# ENG-PUDSP21005-R3-PUDSP.pdf Markup Summary

**Subject:** Callout  
**Page Index:** 1  
**Date:** 4/15/2022 3:10:03 PM  
**Author:** Ryan Howser  
**Color:** ■  
**Layer:**  
**Space:**  
**Page Label:** [1] WB PUDSP 3.10.22-Cover

SHEET TITLE: NORTHEAST AREA DEVELOPMENT PLAN

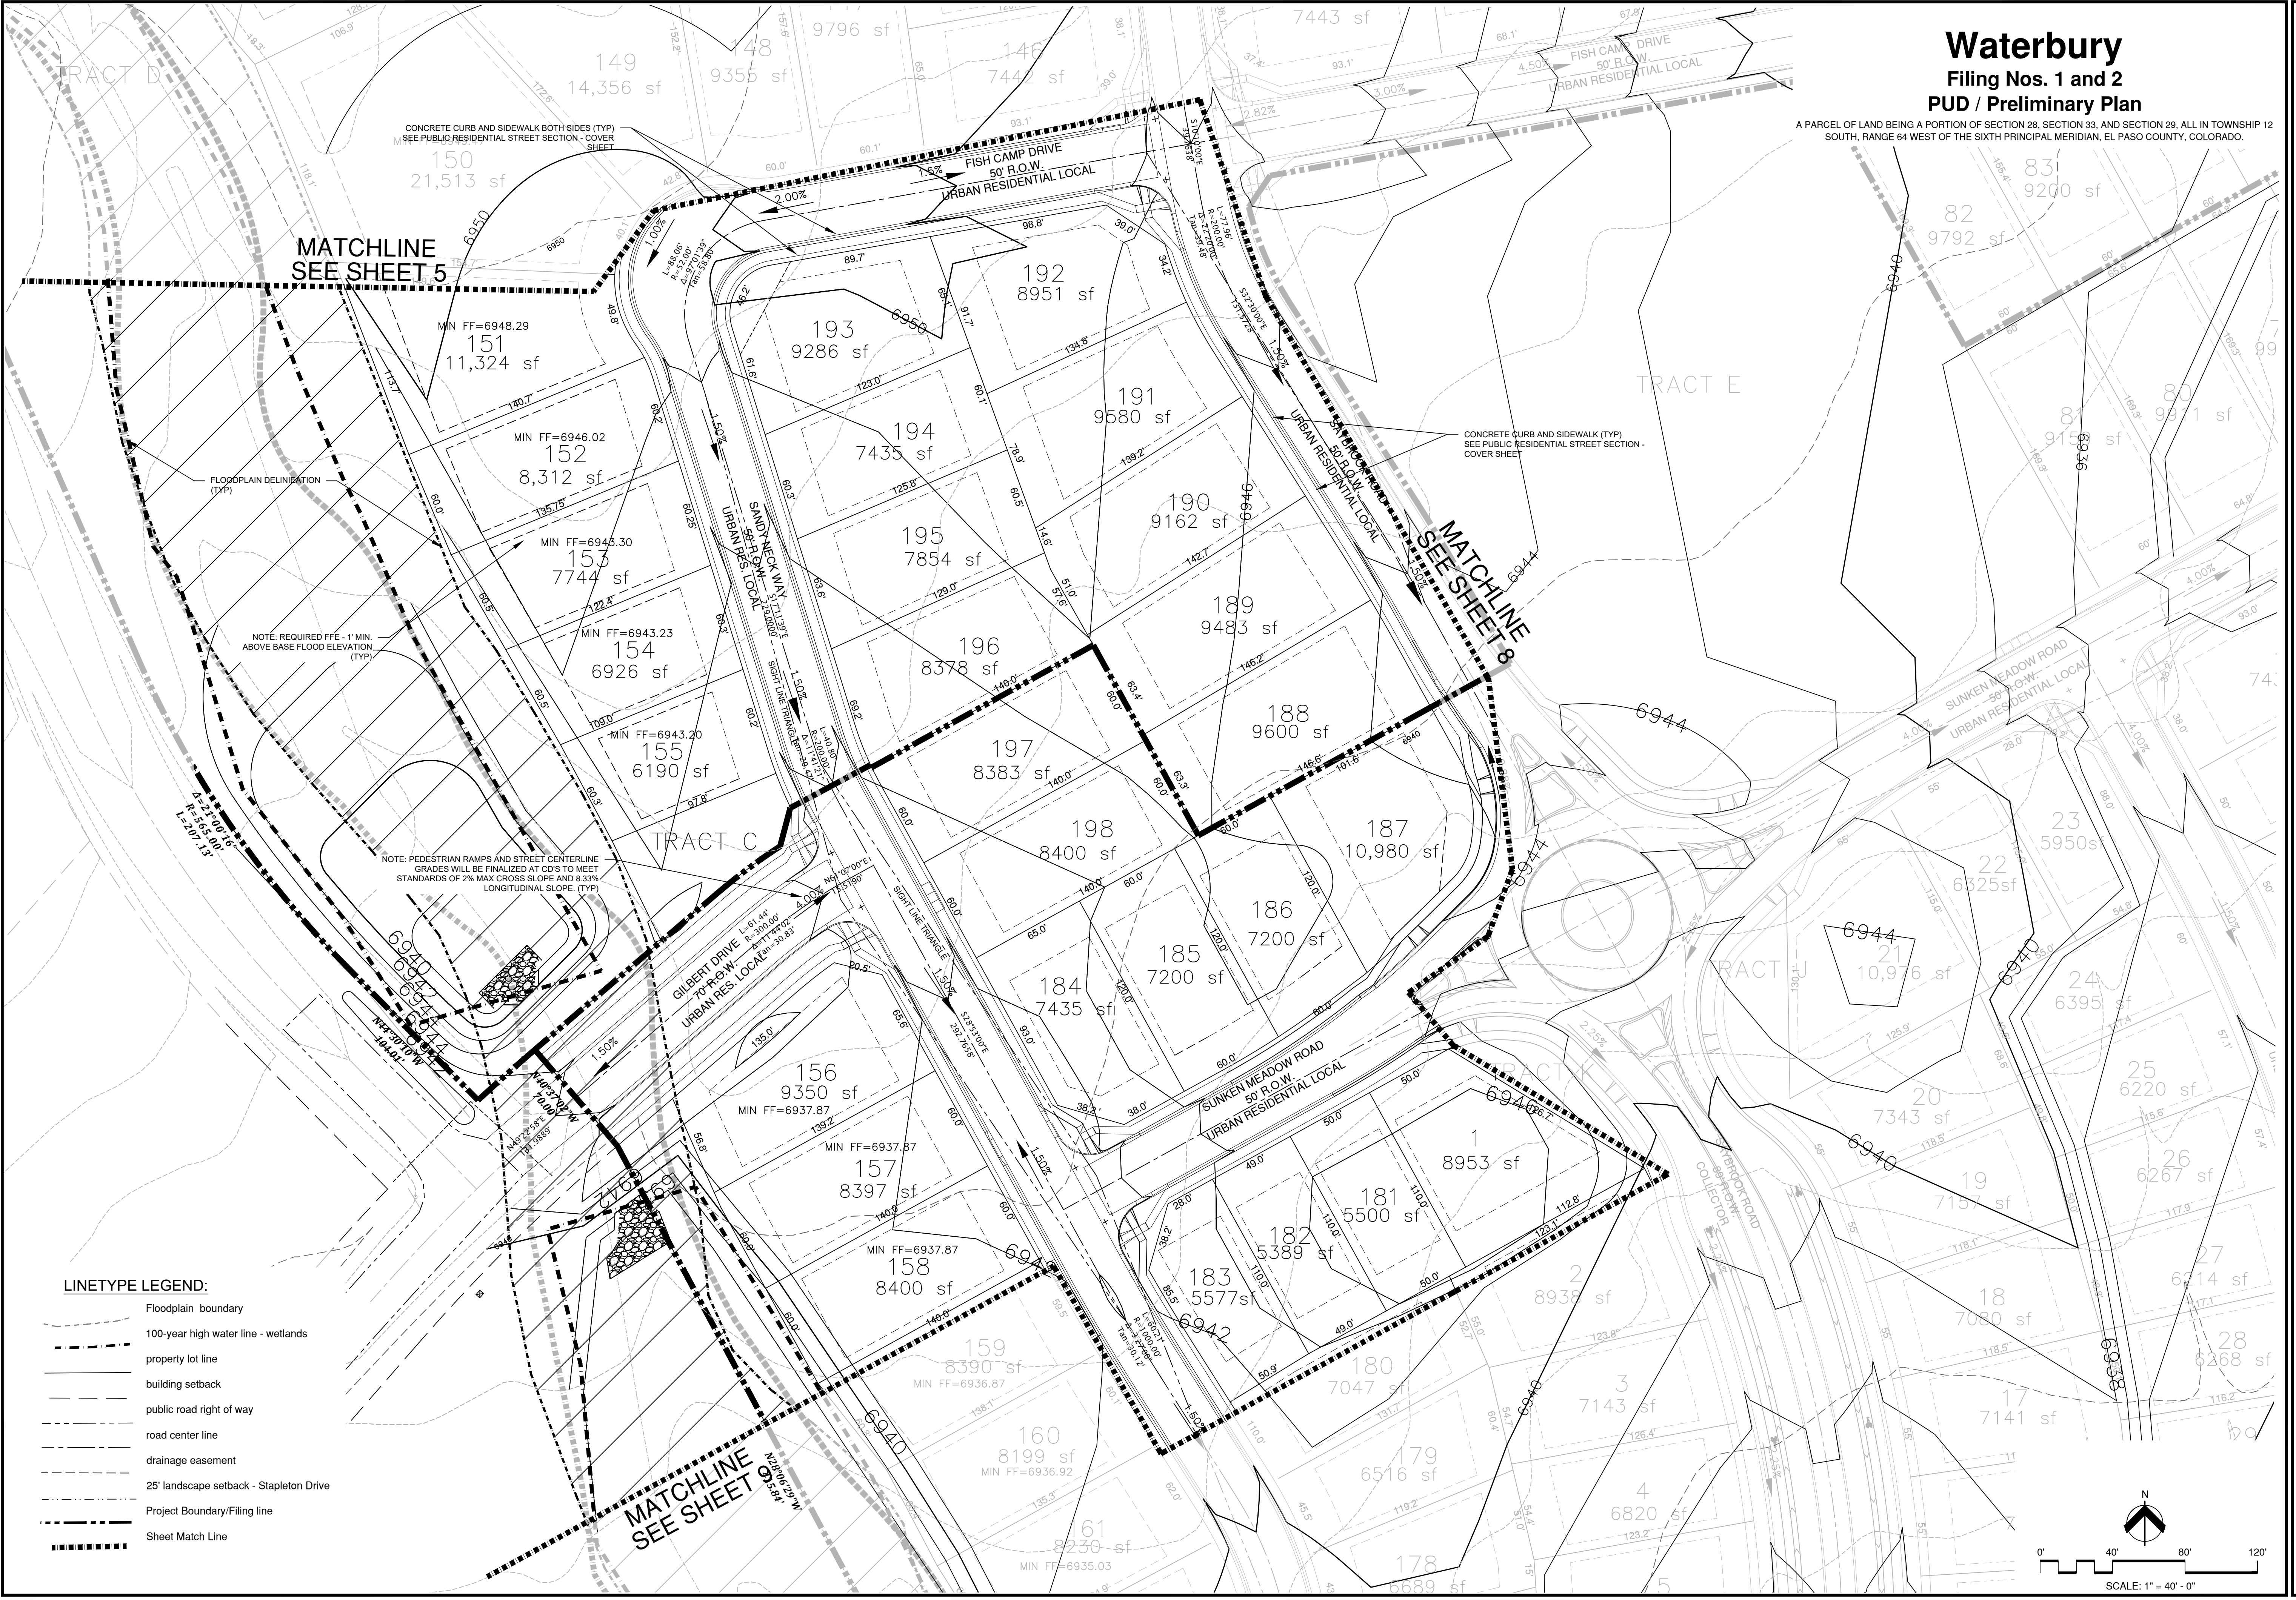
Missing sight line

Label sight line triangles

Extend line to ROW

SHEET NO.  
**10**  
10 OF 14 SHEETS  
FILE NO.  
**PUDSP215**

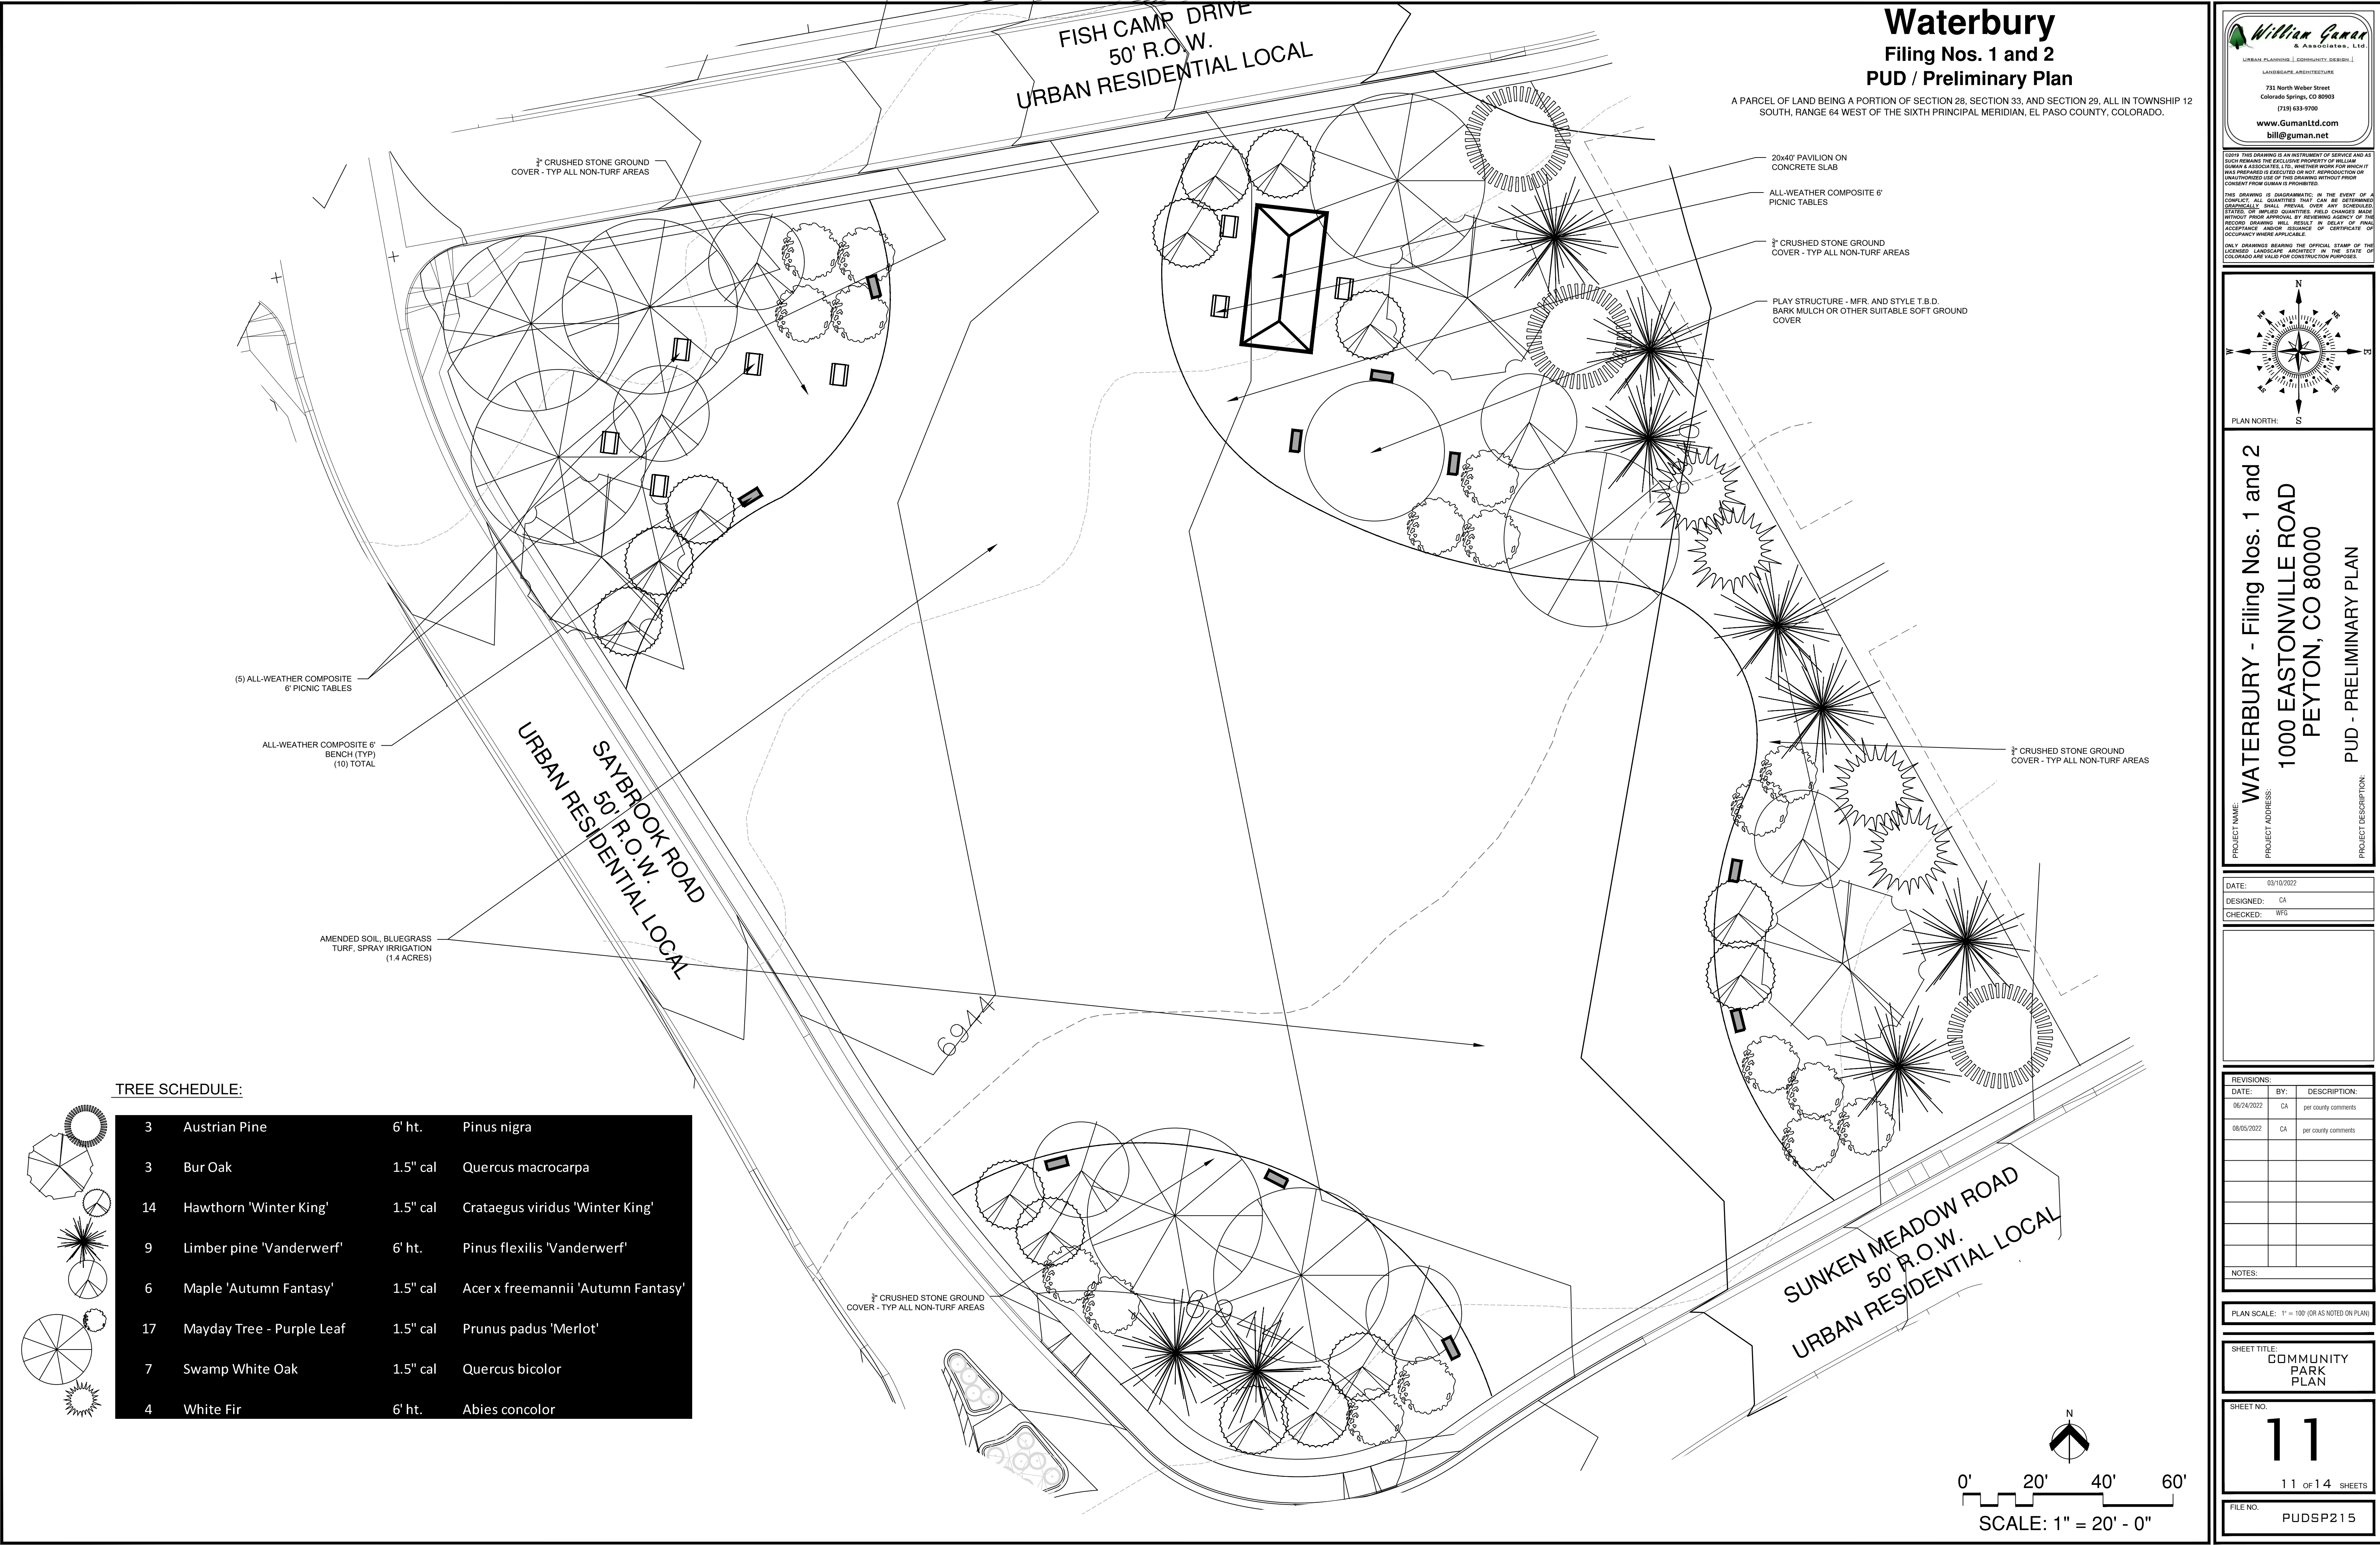
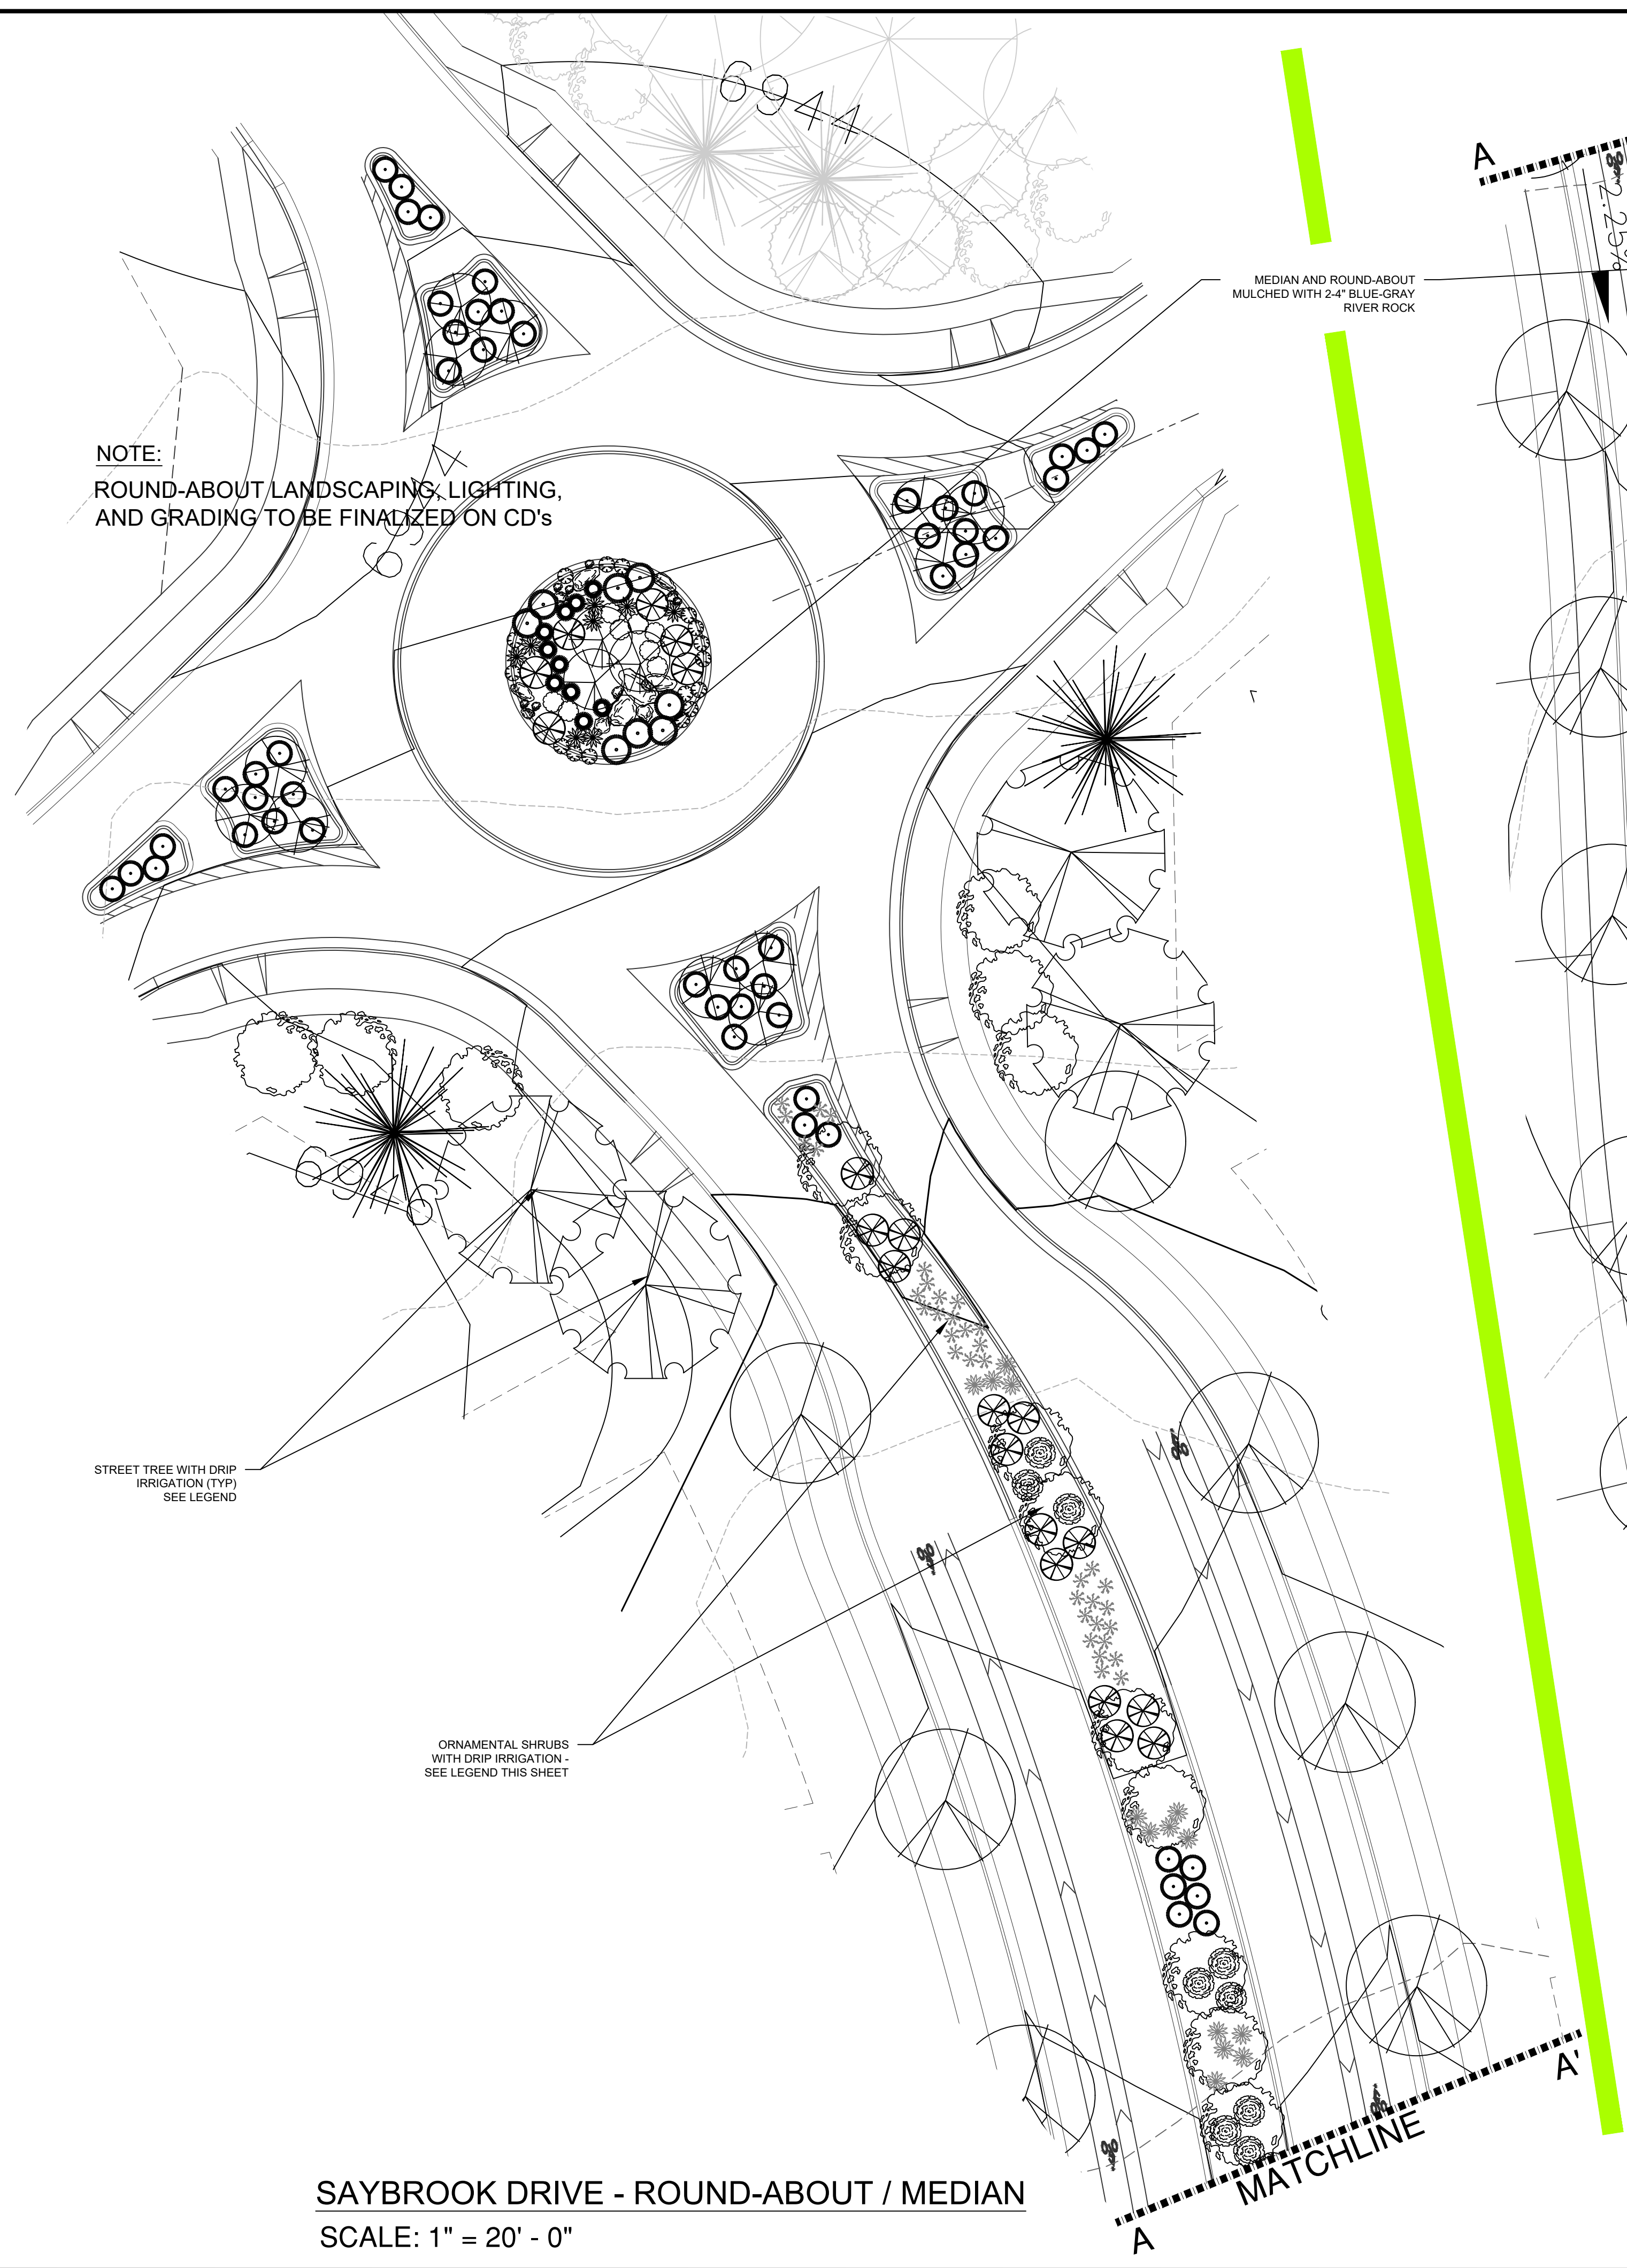
label interim pedestrian facilities

Show and label all areas required to be vegetated and maintained by the district for runoff reduction purposes. (Other sheets also)

Show the wetland hatching
